RESPONSE TO SUBMISSIONS - Section 96(1a) amendment to SSD 14 6387 at 1 Burroway Road, Wentworth Point

This letter provides a response to the issues raised by the Department of Planning and Environment, Sydney Olympic Park Authority and the City of Parramatta in response to a Section 96(1a) proposal to modify Development Consent SSD 6387 for a mixed use development at 1 Burroway Road, Wentworth Point to provide a canopy structure over the central open air plaza area as well as the addition of a small café at the southern end of the central open air plaza.

Project Title
JEWEL RETAIL
1 BURROWAY RD, WENTWORTH POINT, THE WHARF SITE.
SYDNEY OLIMPIC PARK
Drawing Title
CAFE DESIGN

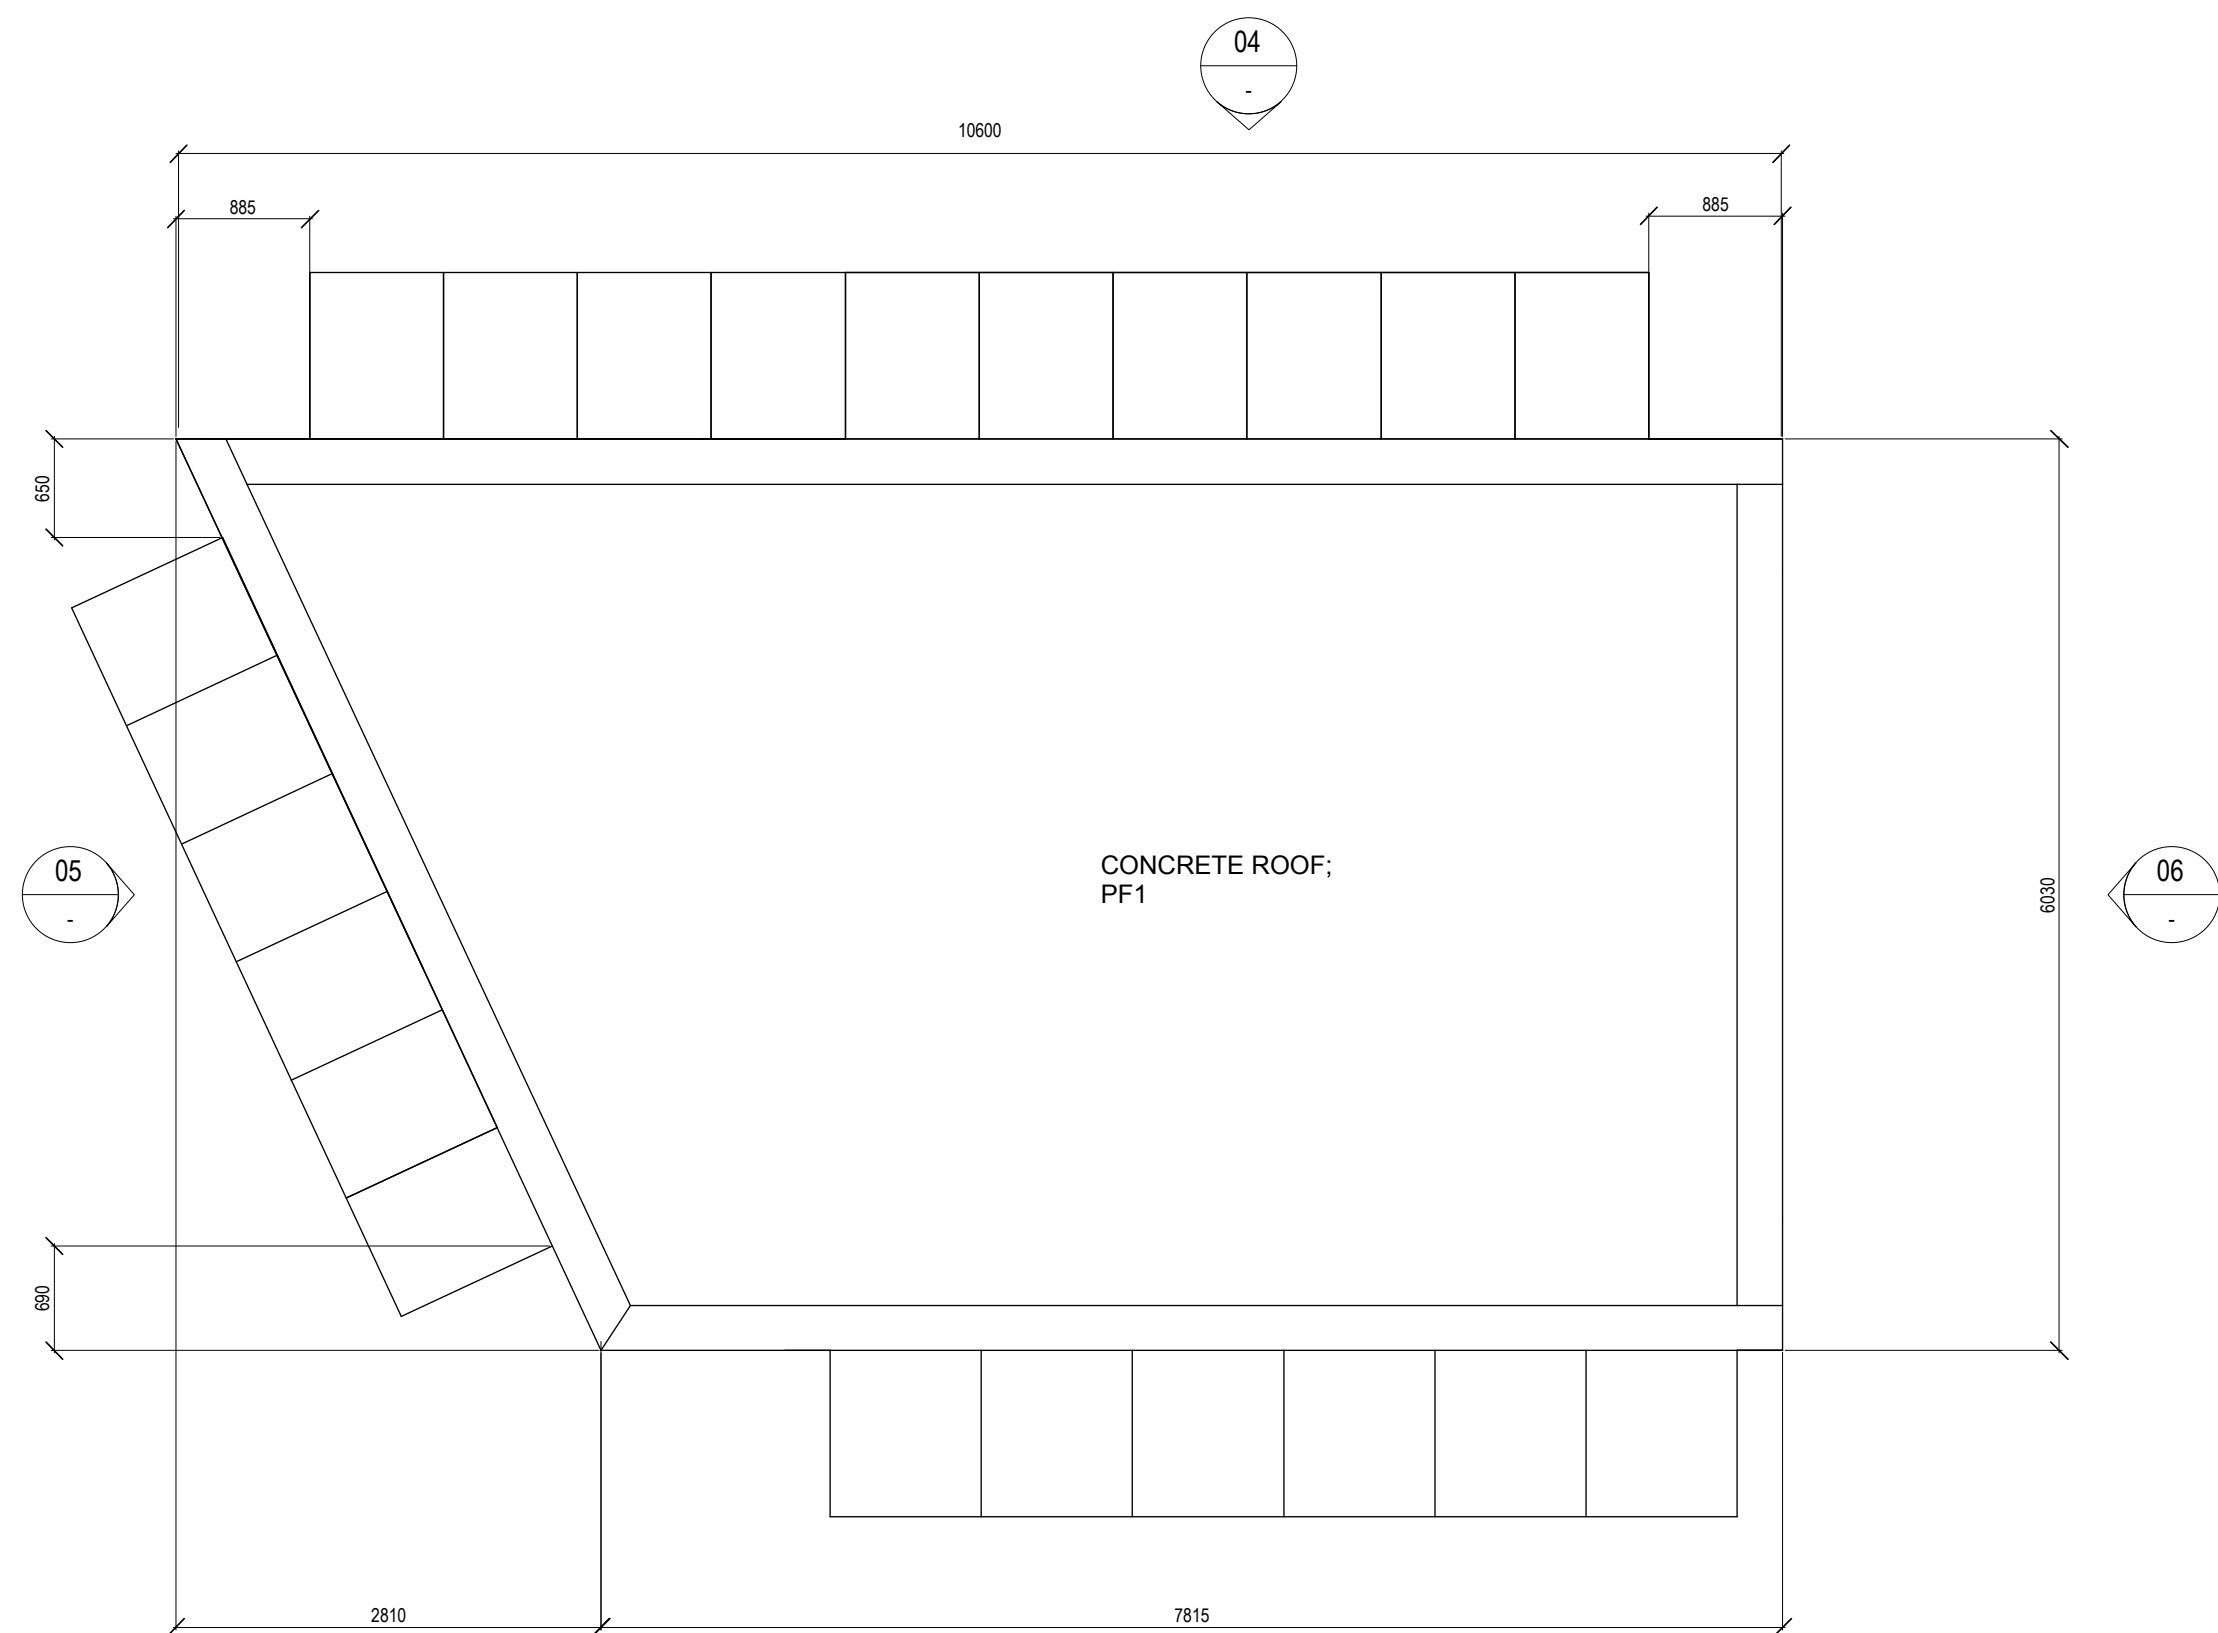
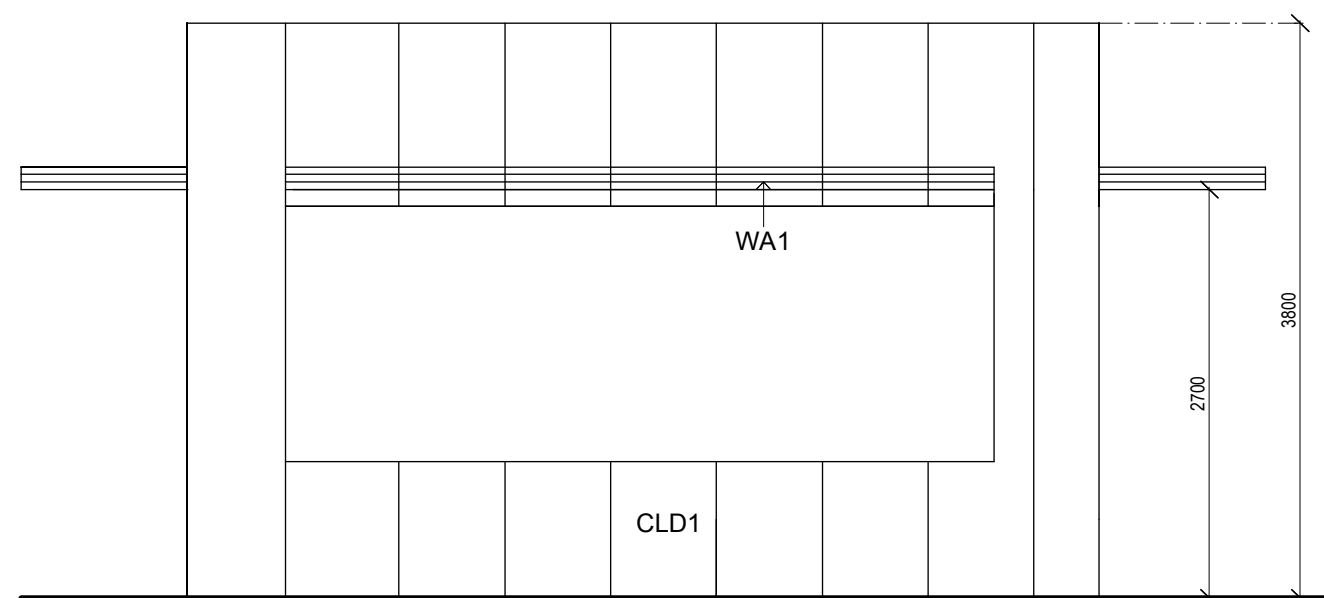
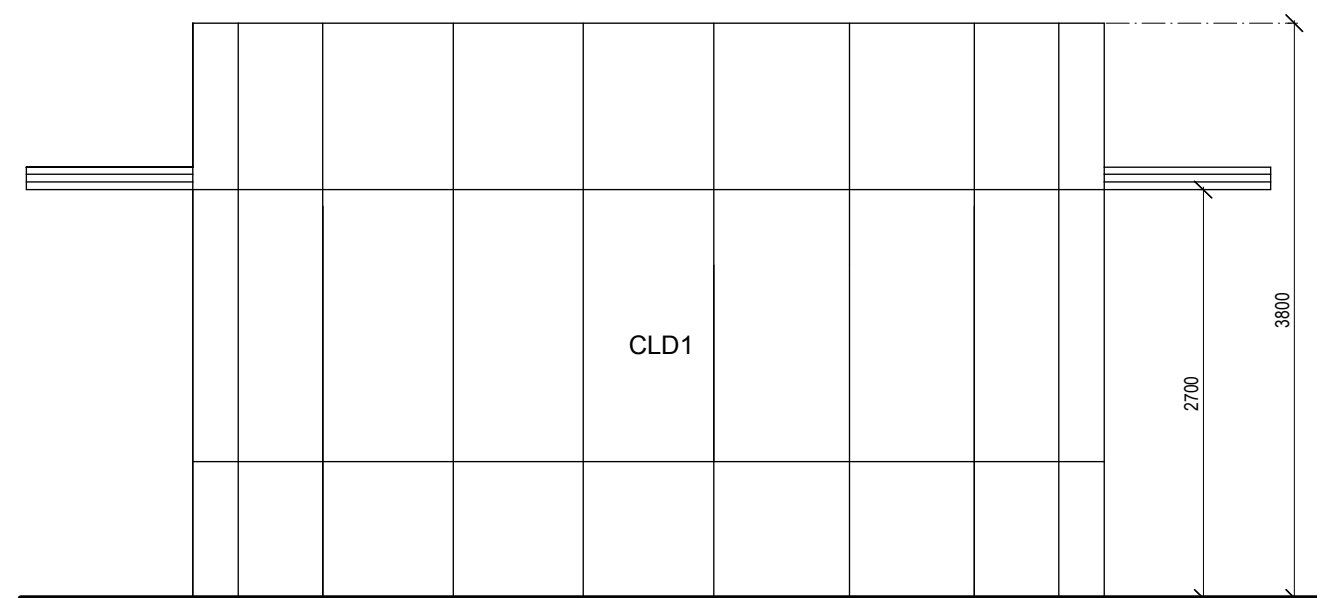
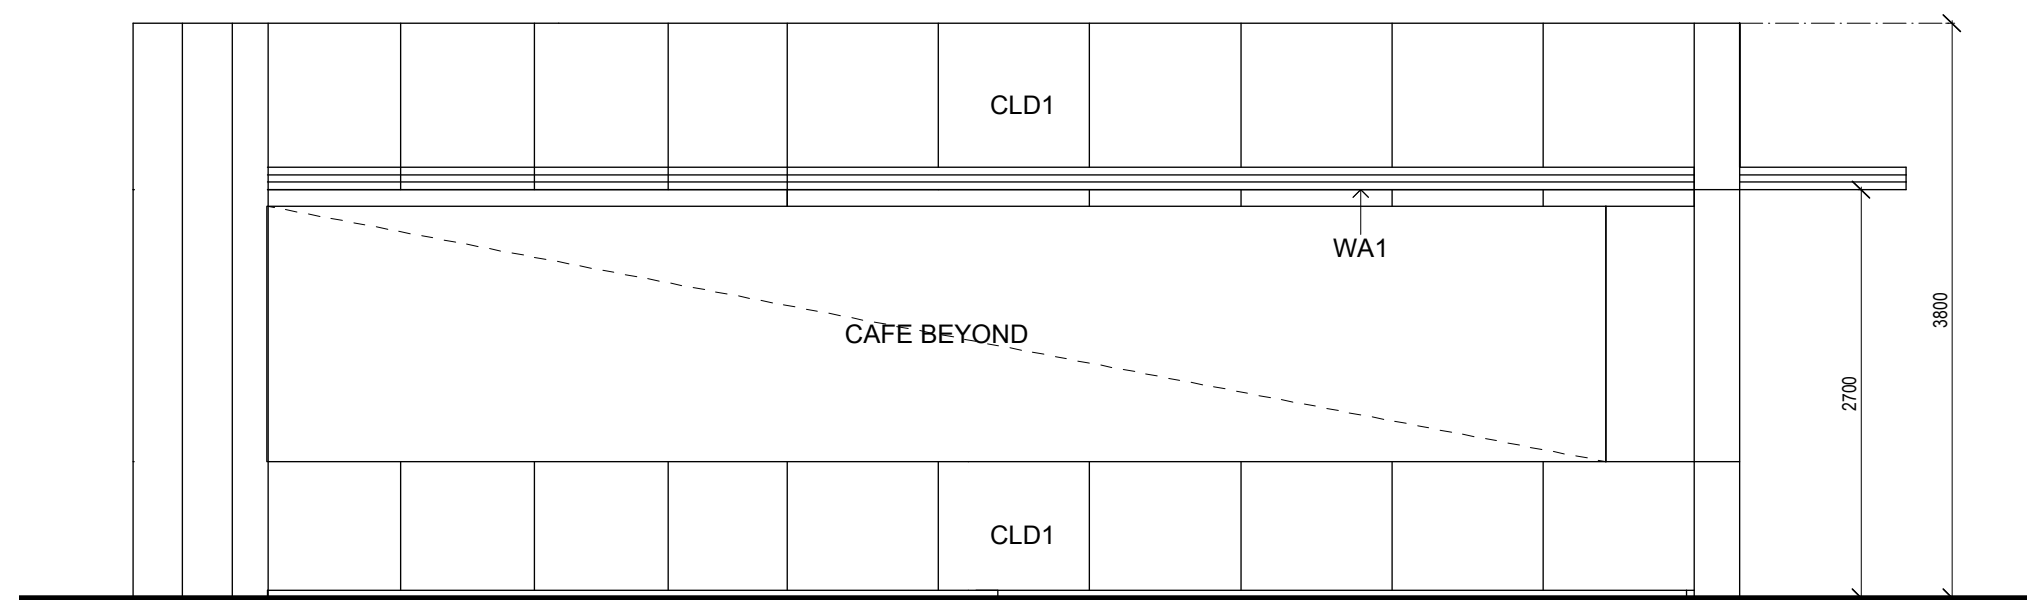
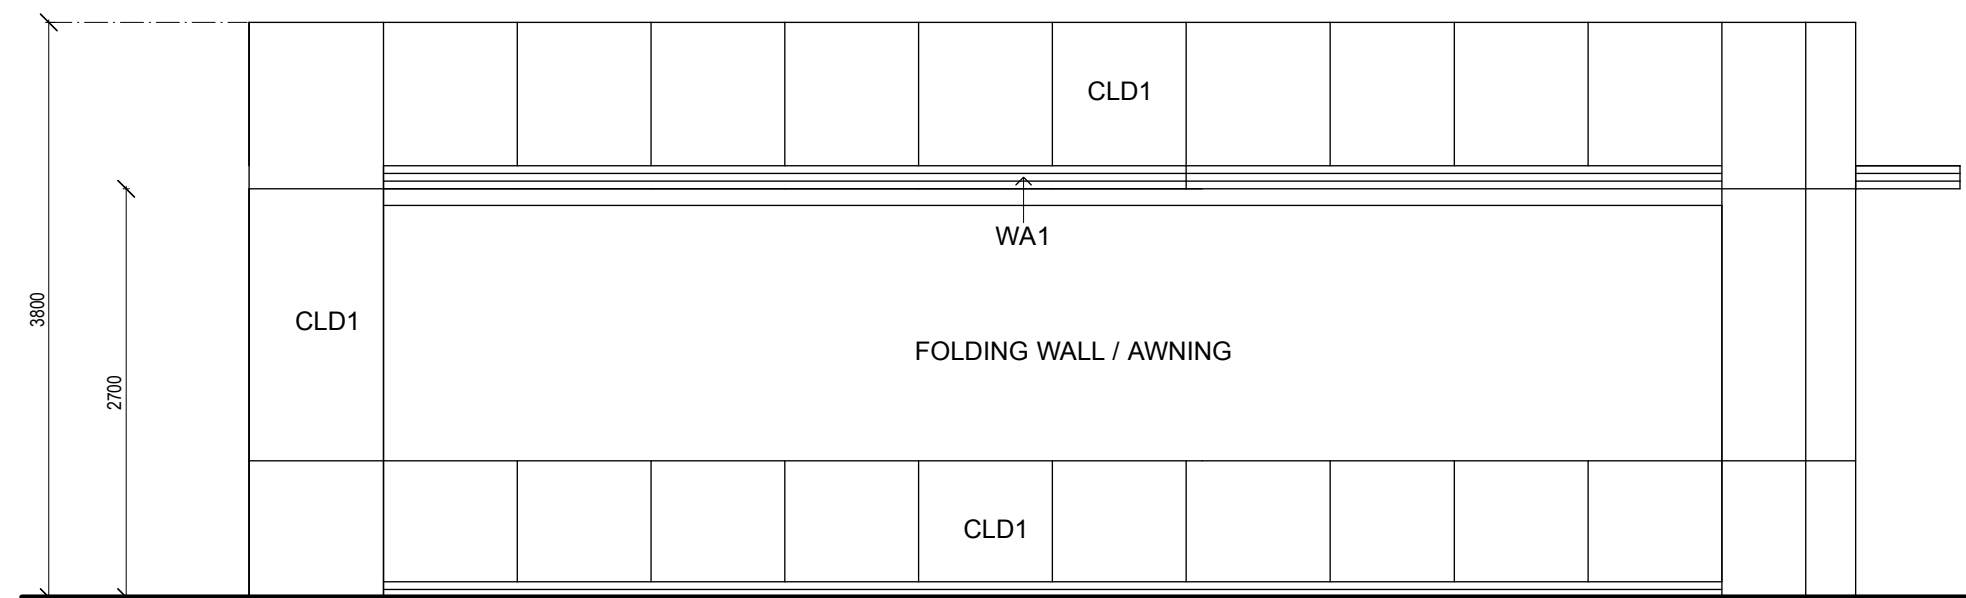
<p>Proposed Café</p> <p>Significant concern is raised with the proposed location of this café. It is a single high structure standing at 3.8m high. It is located at the southern end of the plaza and impedes the visual connection from Burroway Road through the plaza towards the water and the ferry terminal. It also utilises an area which is the gateway to the plaza and impacts upon pedestrian usage (including impeding pedestrian flow). The pedestrian entry to the ferry terminal needs to be clearly defined within the streetscape. It is considered that whilst a café may be an appropriate use within the development site, it should be contained within the ground floor retail component of the development, and not encroach on pedestrian areas. With respect to the above, it is considered that the proposed location of the café does</p>	<p>The proposal has been amended to reduce the café to 30 square metres in area as well as offsetting the café from the through site link in order to maintain a 10 metre dimension for the entirety of the through site link.</p> <p>Therefore, the concerns in relation to visual permeability have been adequately resolved. Furthermore, the café is considered to achieve an important function of activating this gateway area at the entrance to the site which is critical to avoid this large area becoming a sterile space which fails to properly engage with Burroway Road.</p> <p>The amended location of the café complies with the 5 metre setback requirement from Burroway Road and the 10 metre required width of the through site link as prescribed by the SOP Master Plan 2030. The</p>

This correspondence is accompanied by amended architectural plans as a response to the issues which have been raised. The amended configuration has reduced the size of the proposed café to 30 square metres and has relocated the cafe so that it is no longer within the primary through-site link.
